**Lancashire  
Constabulary**

### **Crime Impact Statement**

Planning Application 3/2016/0193 Reserved matters for the detailed approval of appearance, landscaping, layout and scale for the erection of 118 dwellings (Phase 1) at Land East of Chipping Lane, Longridge

Job	CHIPPING LANE LONGRIDGE		
Title	BOUNDARY TREATMENT DETAILS		
Design By	Date	Drawing Number	Rev
AA	10-02-2016	459/ BTD01	
Drawn By	Scale @ A1		
AA	1:50

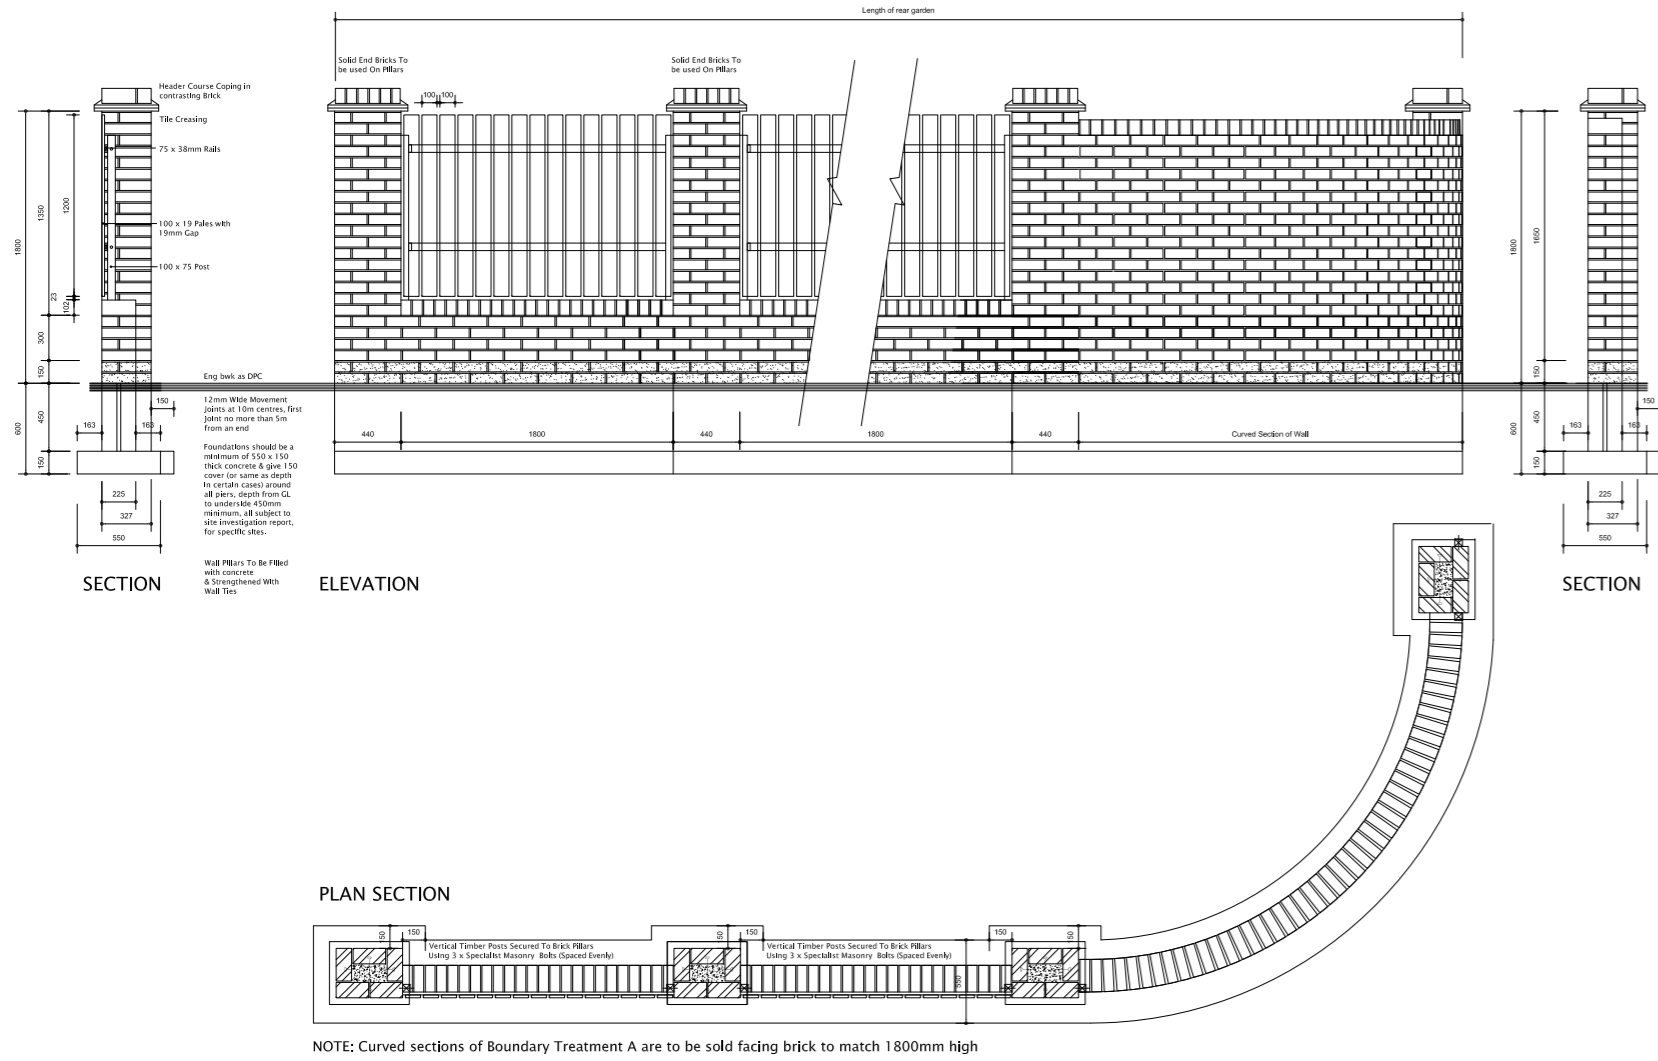
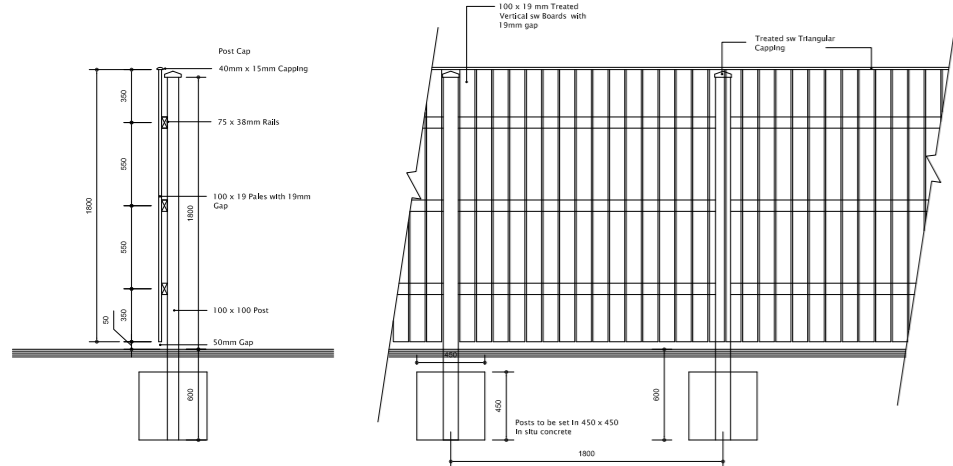
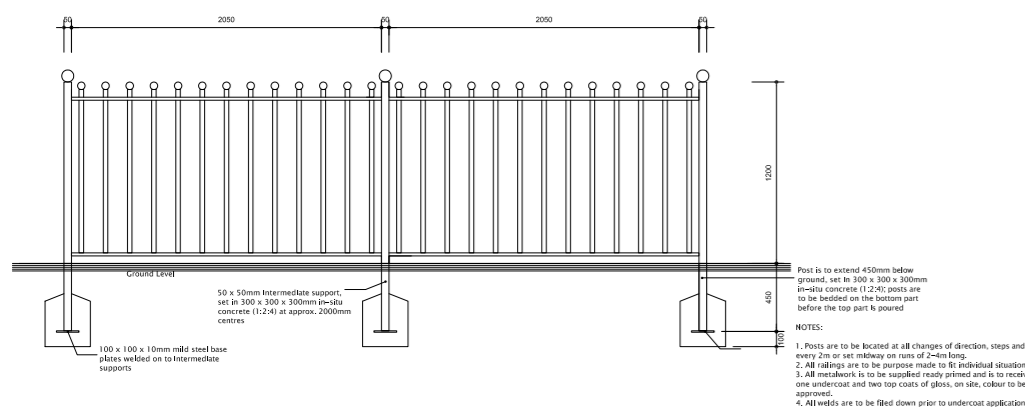
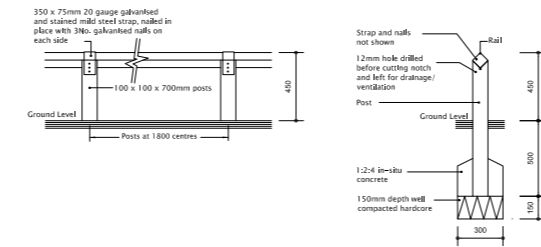
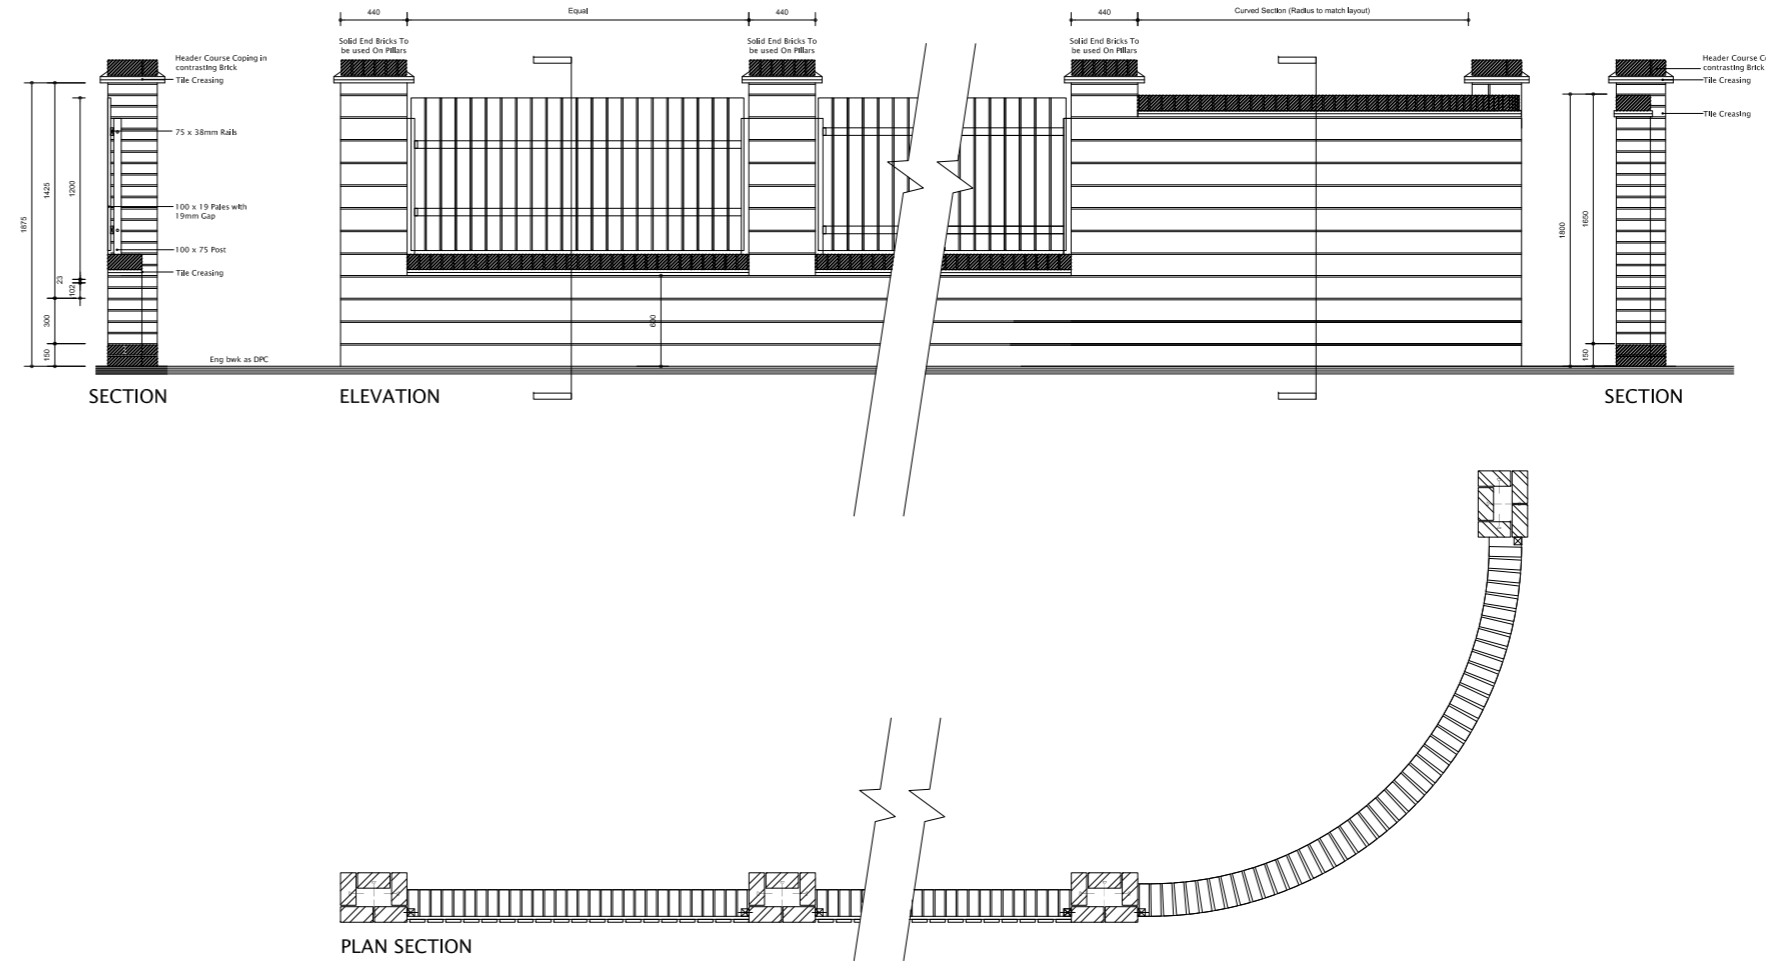
- The boundary treatment layouts show that rear access gates are located at the rear of the gable elevation. These should be brought forward as the current plan allows access to an area of private space which is hidden from the general street view and is therefore more vulnerable to crime. Simply bringing the gate forward eliminates this risk as suspicious behaviour to climb over or force open the gate would clearly be visible from the street and therefore far less likely to occur. Moving the gate forward would have no associated cost implication.

- All proposed boundary treatments are appropriate to the risk.
